I strongly object to the approval of SSD 7056. Please see my three original submissions regarding the issues it poses. The applicants' recent responses (May 2016) show that they have done little to address these and worse still, that at least some of their consultants, have not considered them worthy of a response. The submission which follows is my specific response to this amended SSD application.

The amended application retains the same misleading title, 'Remediation, Restoration and Adaptive Re-Use of Campbell's Stores'. It thus continues to hide the fact that a significant part of the proposal relates to a proposed new four-storey-high building in a space that earlier decision makers determined should be left vacant or, at the most, allow a sun protection

Drawing Title  
**ELEVATIONS**  
JPW Project Number  
12006  
Drawing Status  
EA  
Drawing Number  
EA-A-2000  
Revision  
B

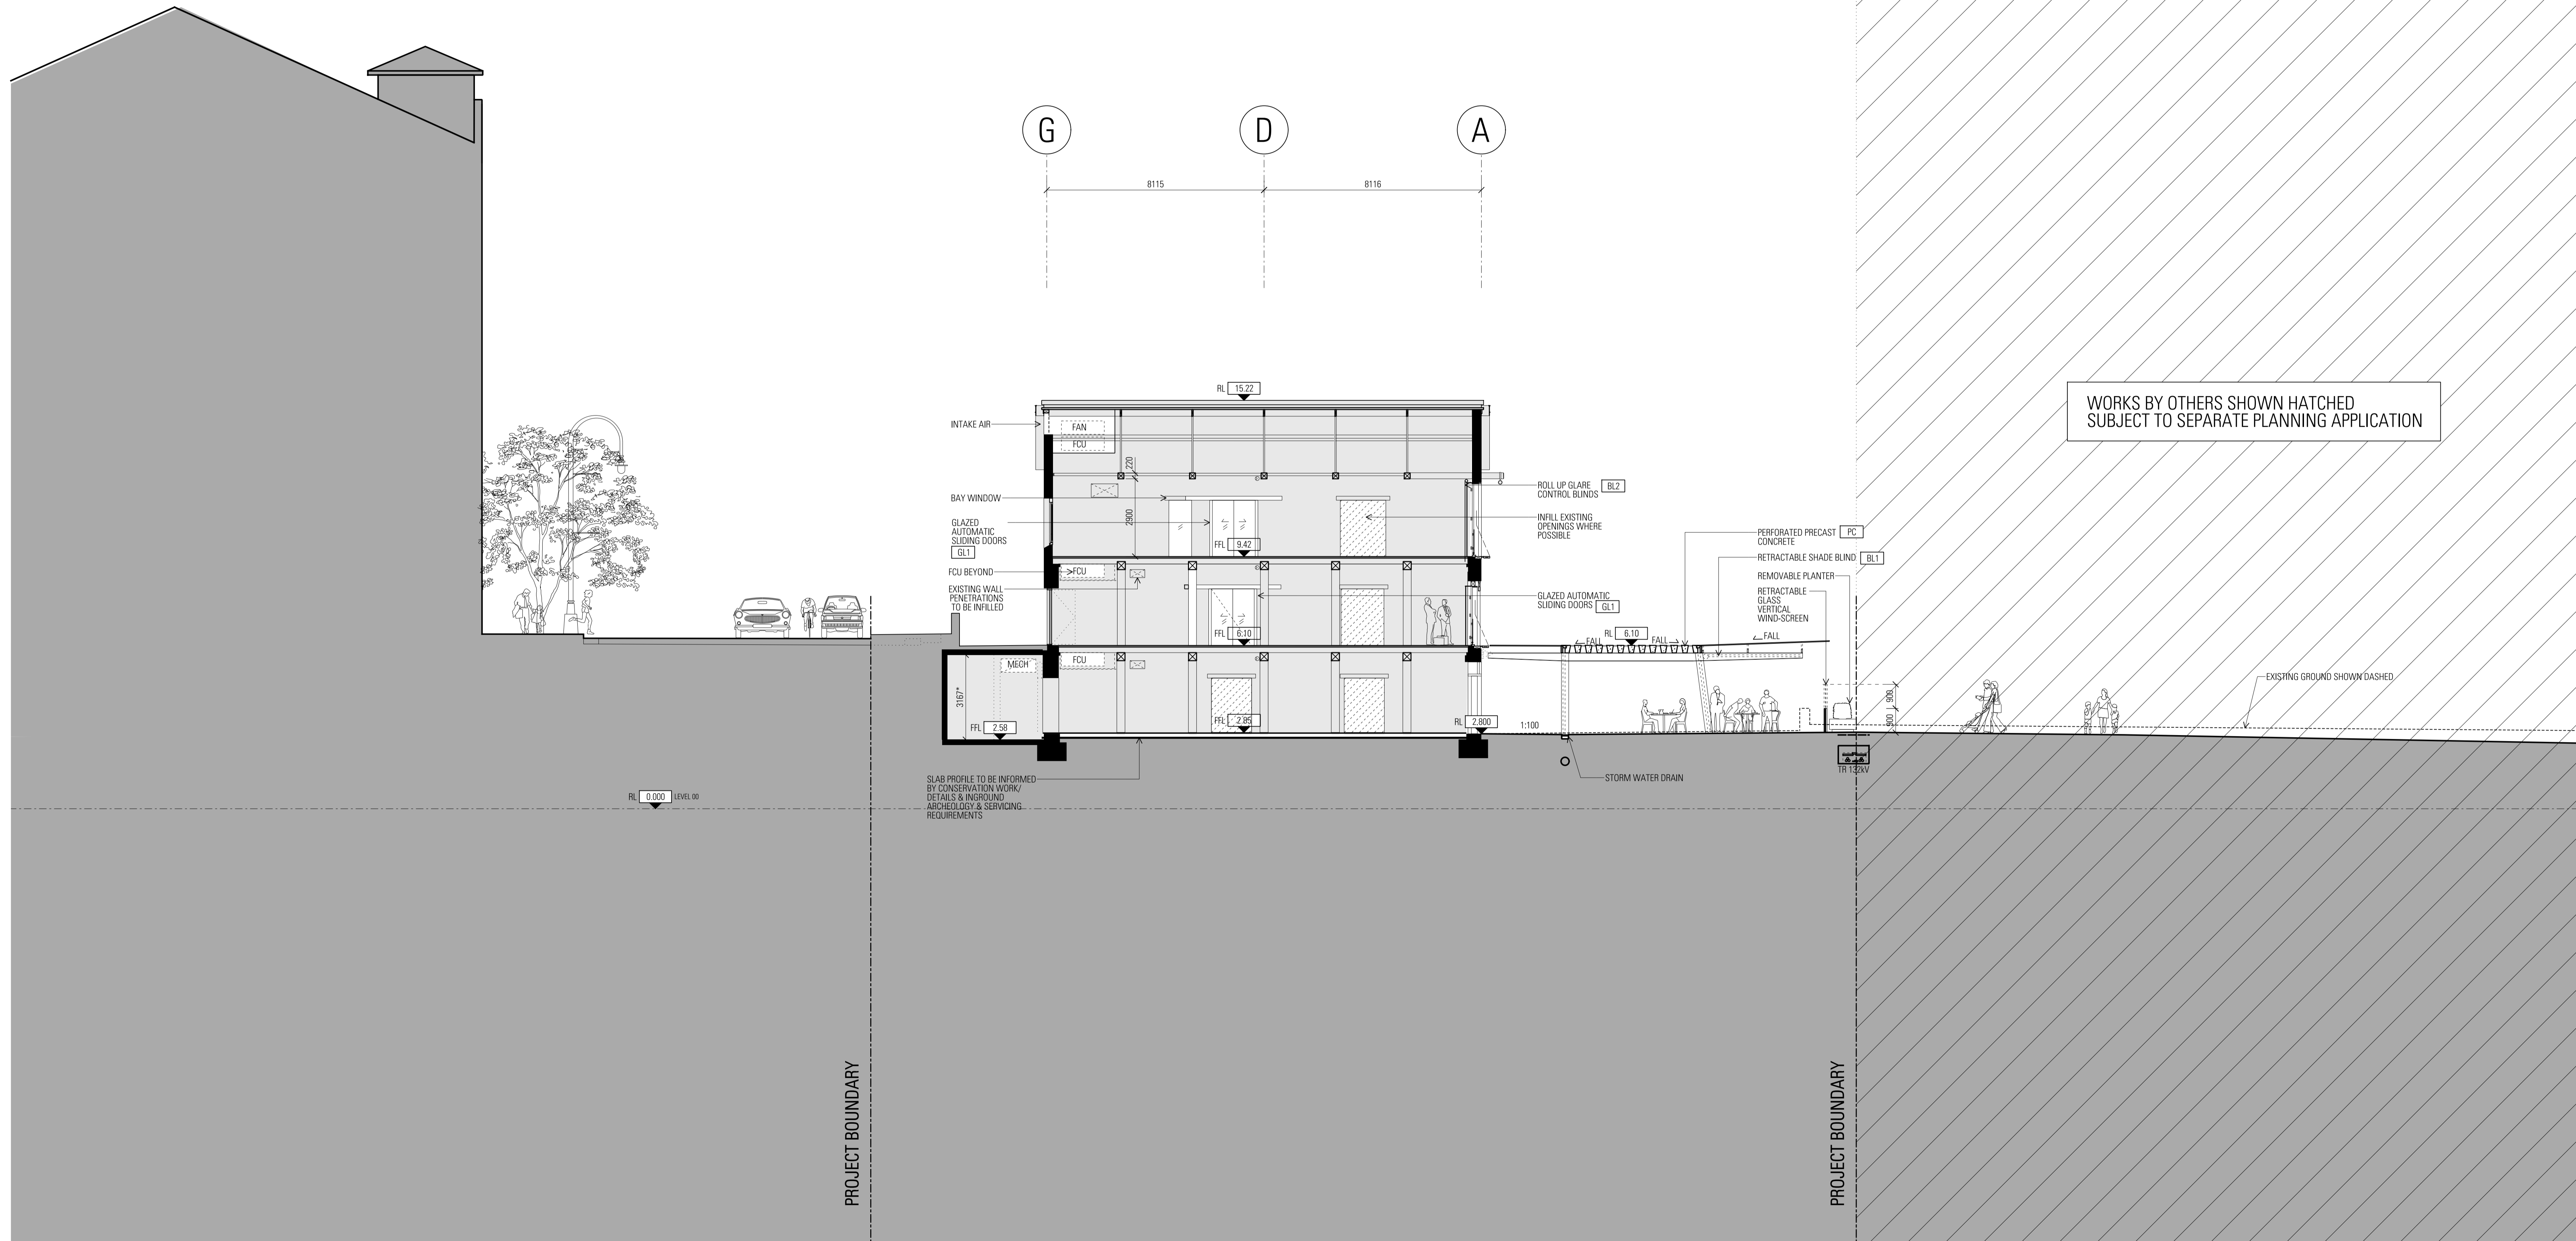
The 'glass box' is the worst of the applicants' proposals and the amended SSD application does little to address criticisms of it. Effectively a bulky glass box on stilts, the proposed new building, even with its reduced height, would still dominate the Hickson Rd streetscape and the Campbell's Cove foreshore. It would have no visual or aesthetic relationship with Campbell's Stores on one side of it or the sympathetic, modern lines of the Park Hyatt Hotel on the other. It would look like it had been parachuted in and create a sense of crowding and over-development in what was intended as open space. The applicants' images misleadingly depict the building as transparent; in reality you wouldn't be able to see through it at all.

The glass box would be a dominant, unattractive addition to the heritage foreshore. This is clearly shown in Figure 13, p.35 of the 'Response to Submissions' and in Figures 6.13, 6.15 and 6.16 of p.25 of the Appendix B1 Design Response Report, Part 3. The box would create an impression of density and scale out of keeping with The Rocks' character and a sense of overdevelopment by restricting the rhythm of space to built form along both the foreshore and the Hickson Rd streetscape. To accommodate this rhythm, it should be no higher than the gutter level of Bay 11 and two metres narrower, but even then it would be out of place here.

What the drone images do demonstrate is the extent to which the proposed new building is at odds with Hickson Road’s heritage streetscape and colour palate. The glass box would not be transparent as shown. It would be bulky and dominate the Stores’ building. This is in marked contrast to the view of Campbell’s Stores I now enjoy, where what predominates is its gabled bays, saw-toothed roofline, repetition of door and window openings and its simple, warehouse functional, 19th century architecture.

Bay 12

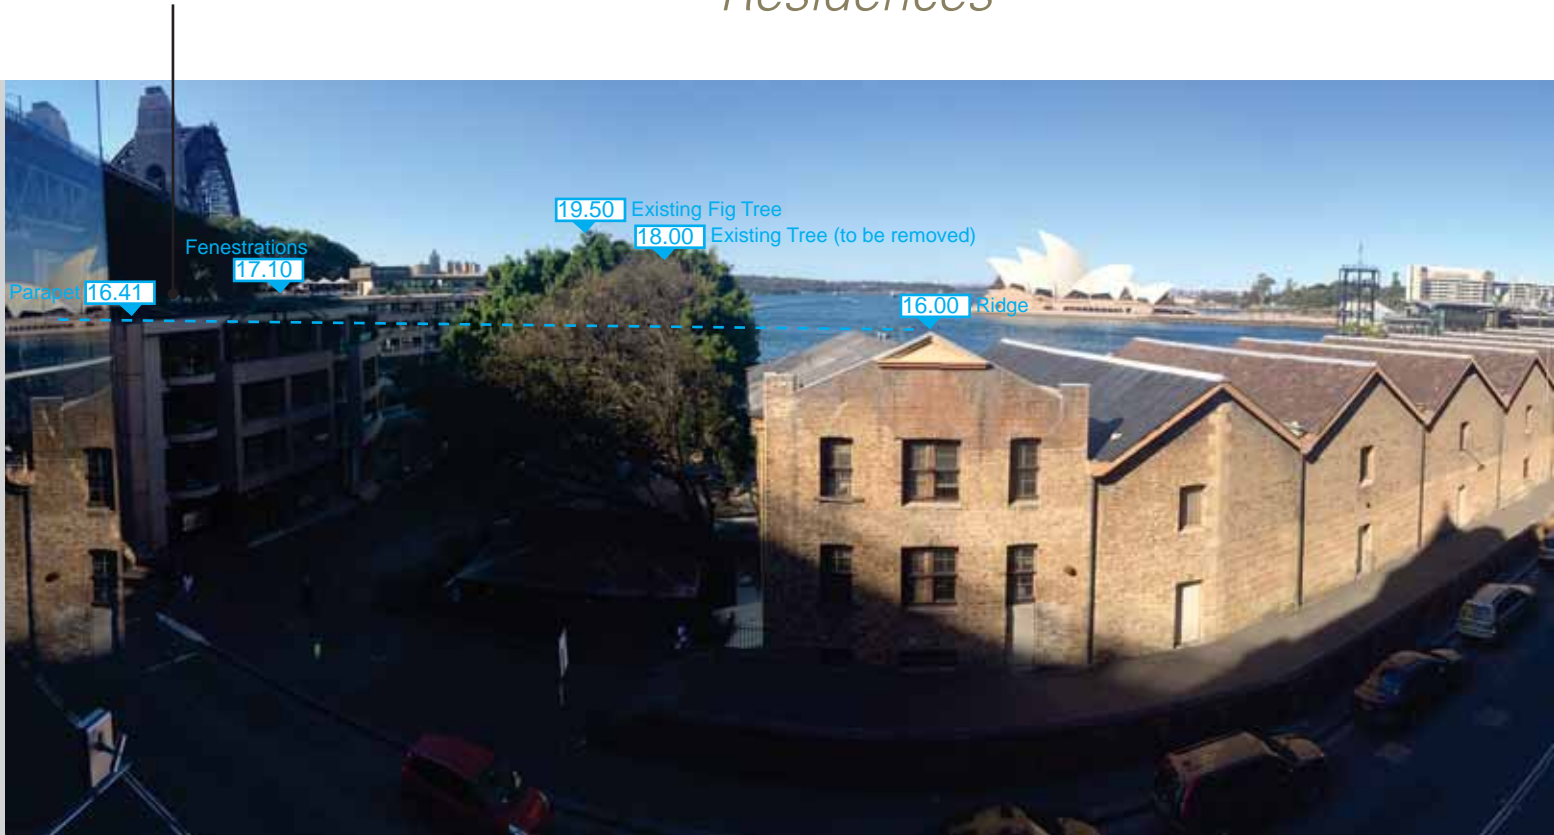
The proponents seem to employ a limited concept of what constitutes a ‘view’, assuming that all views are at eye level. Some apartments at 8 Hickson Road have windows which direct people’s views upwards. For these, the new building might effectively block out both existing views and light. Apartments on the upper levels of 8 Hickson Road might find their views

towards the street marred by lift overruns on the proposed new building and its general roof treatment and by the mechanical exhaust system yet to be designed for Bay 11.
